**Rye Park Wind Farm Modification 1 (SSD-6693-Mod-1)
Request for Additional Information**

I refer to the Rye Park Wind Farm Modification 1 (SSD-6693-Mod-1). After careful consideration, the Department is requesting that you provide additional information.

Over-dimensional and Heavy Vehicle Access

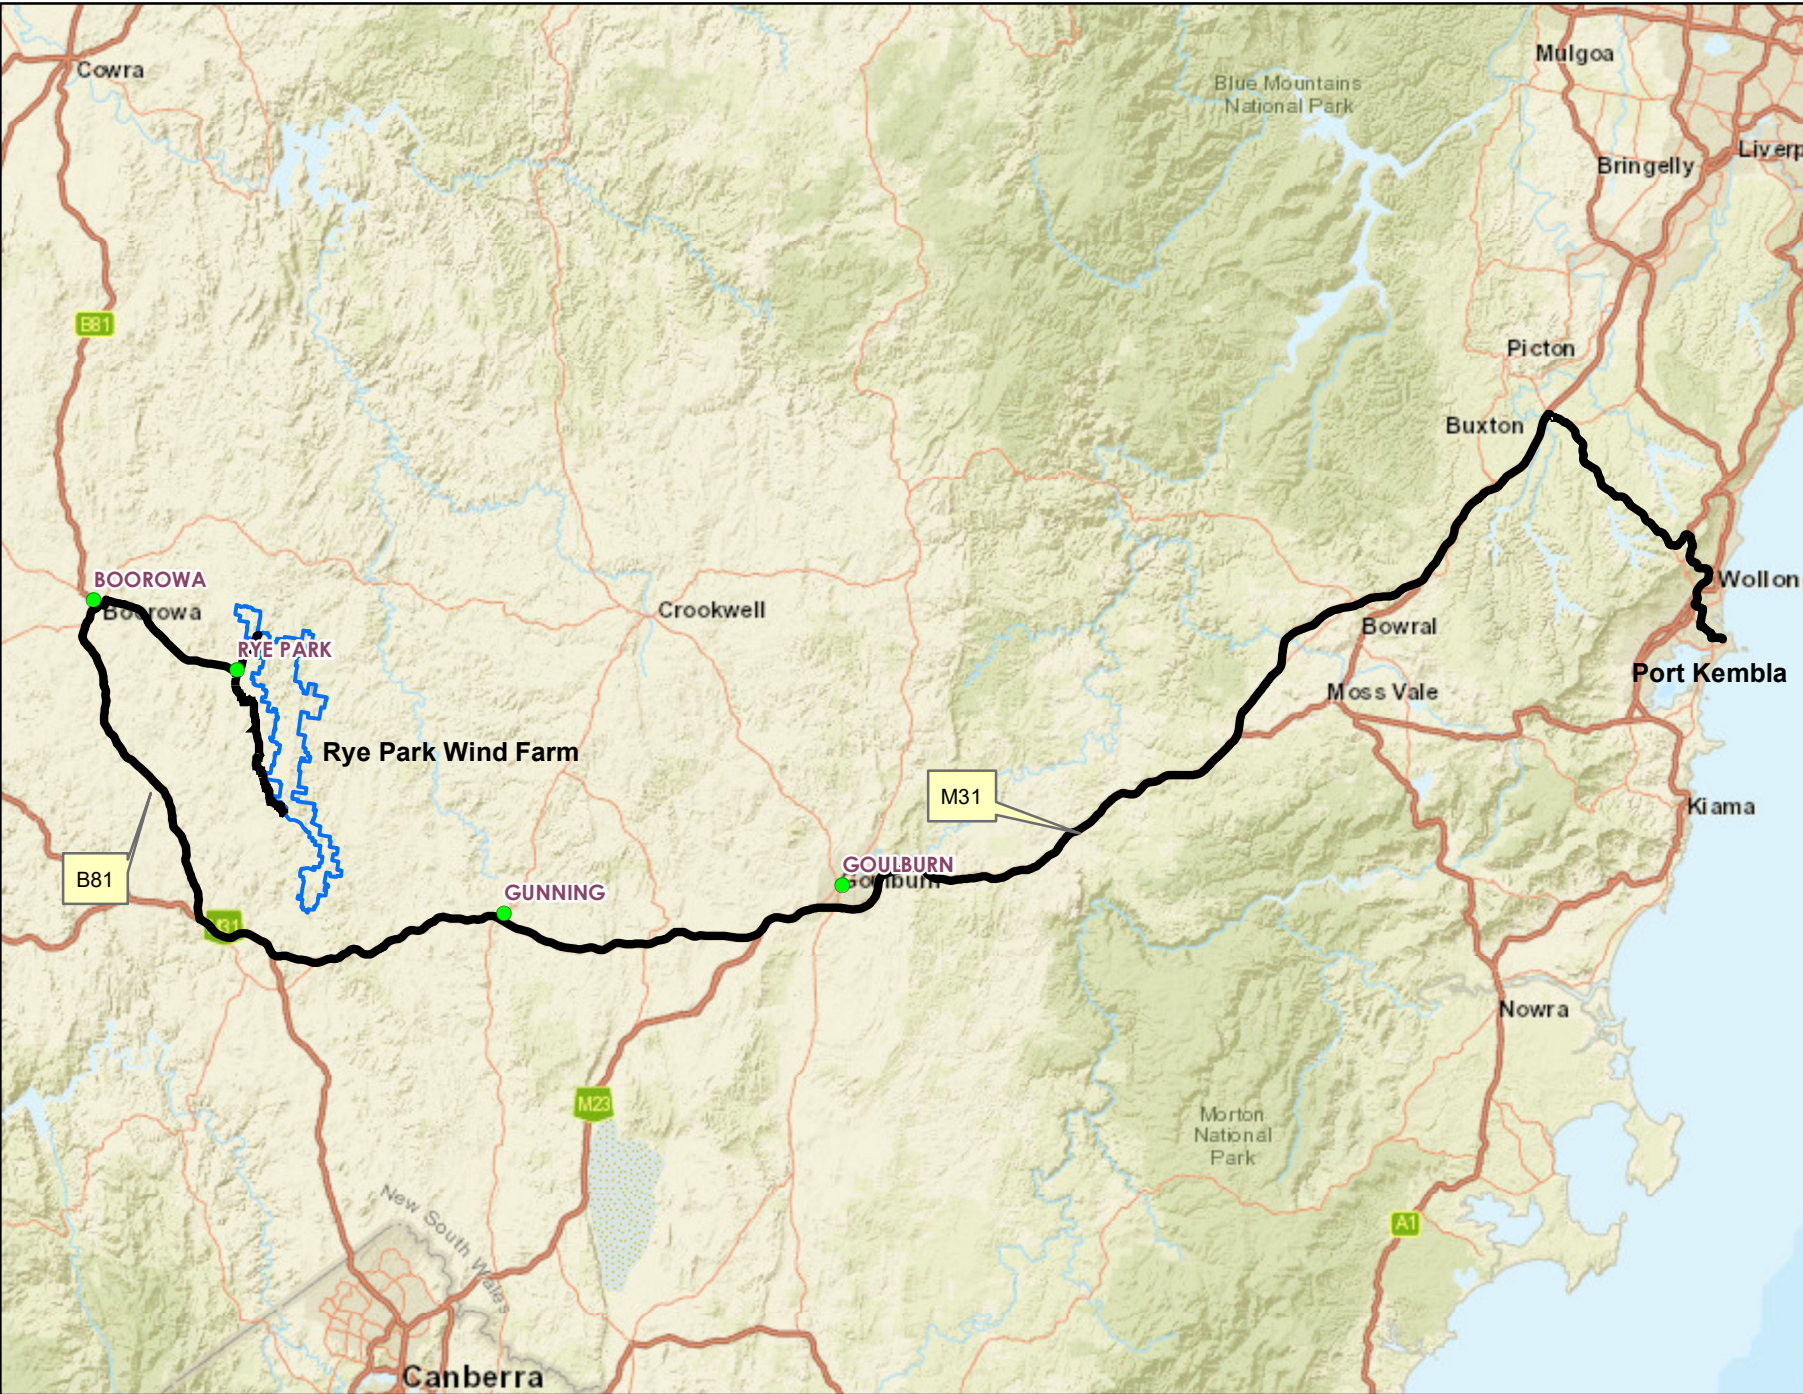
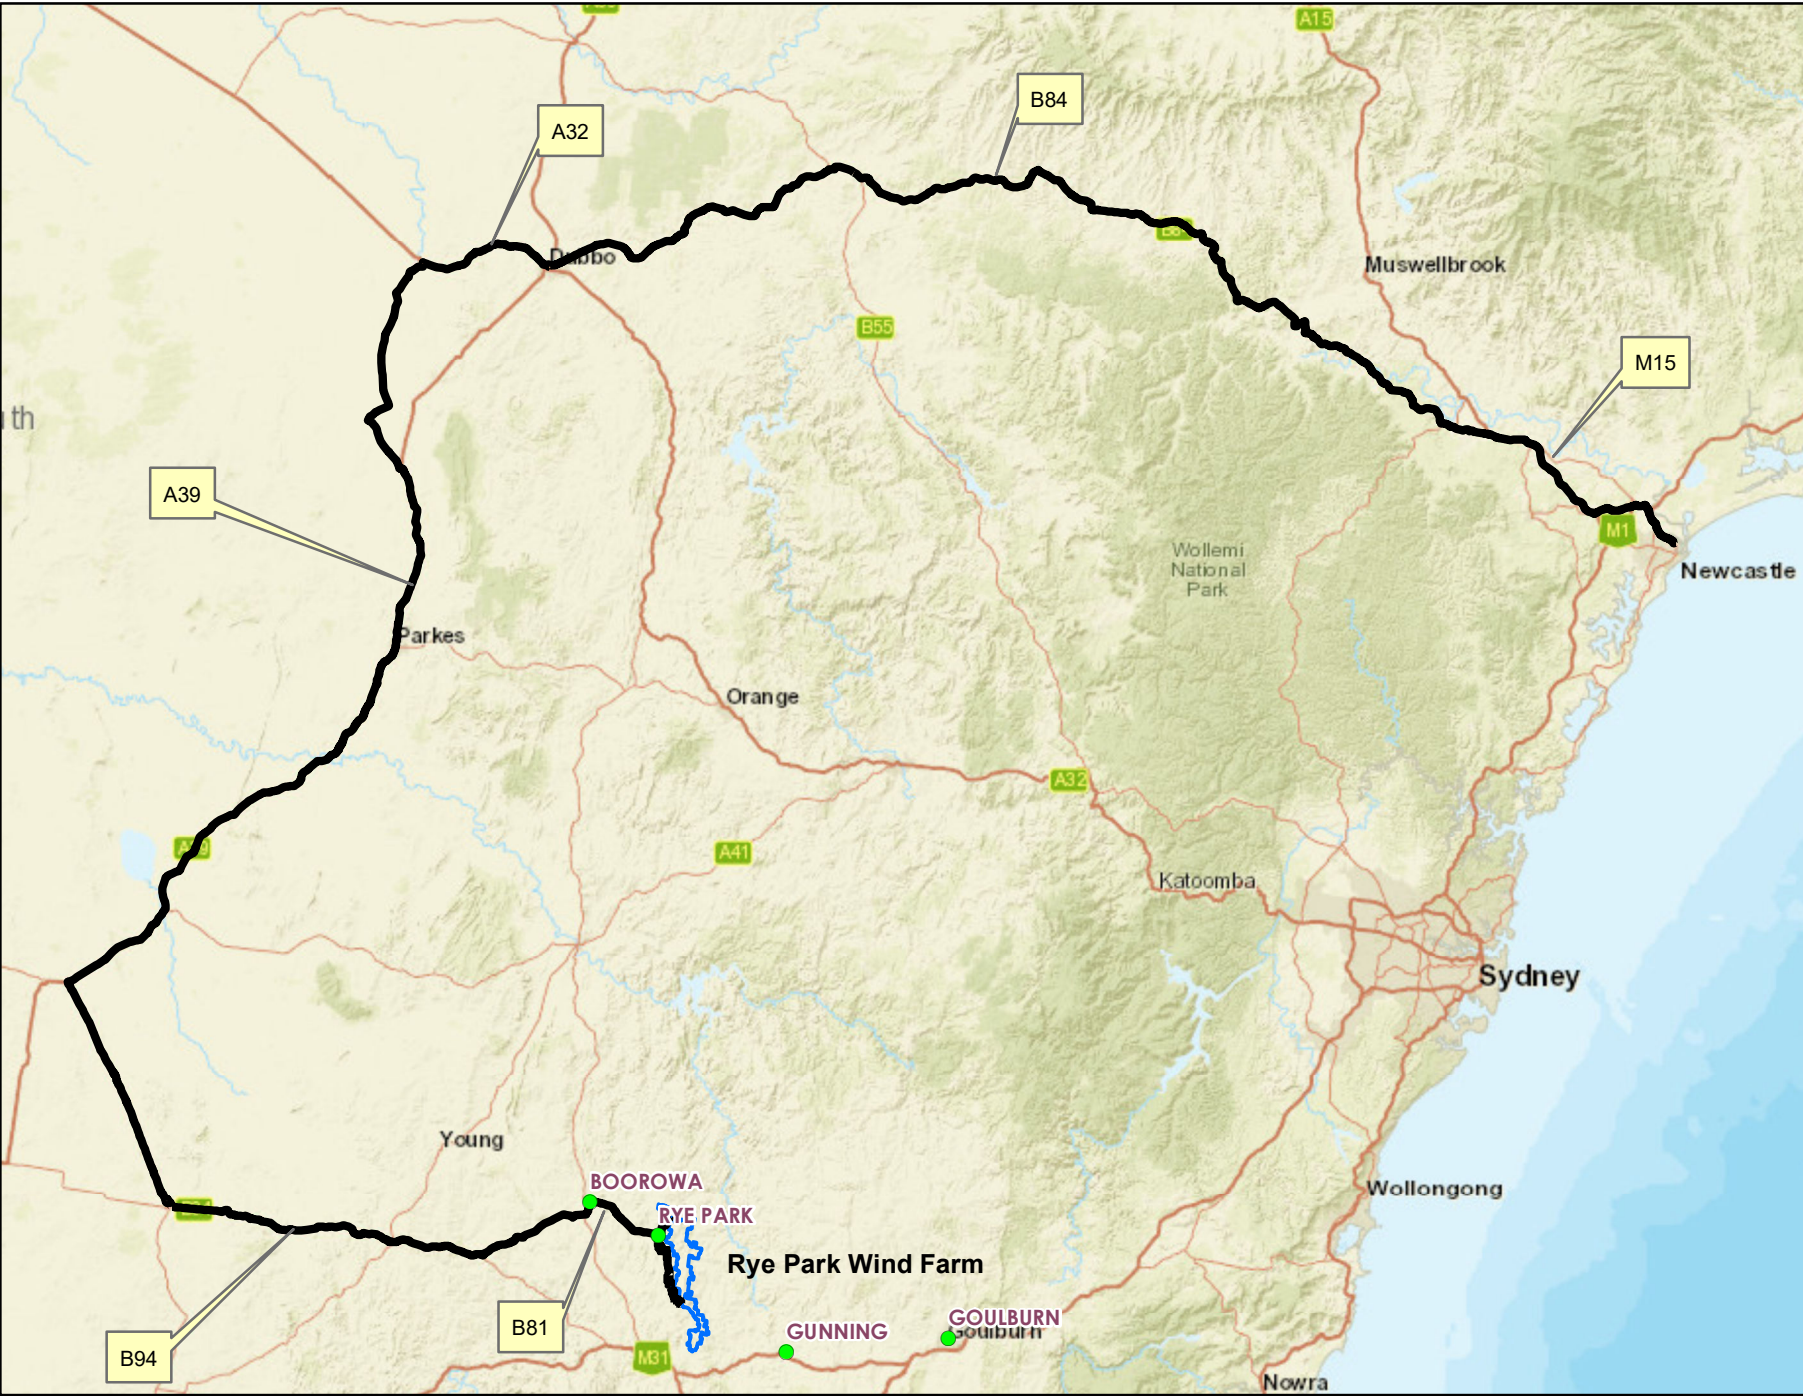
- confirm the maximum blade length proposed;
- detail the number of heavy vehicles using each haulage route;
- document the consultation undertaken with relevant road authorities along the proposed haulage routes, and how matters raised during consultation have been addressed;
- consolidate a list of any intersection upgrades or intersection treatment types required and road infrastructure that would be impacted along each of the proposed haulage routes, ;
- detail the assumptions made for sourcing raw material and their transportation to site.
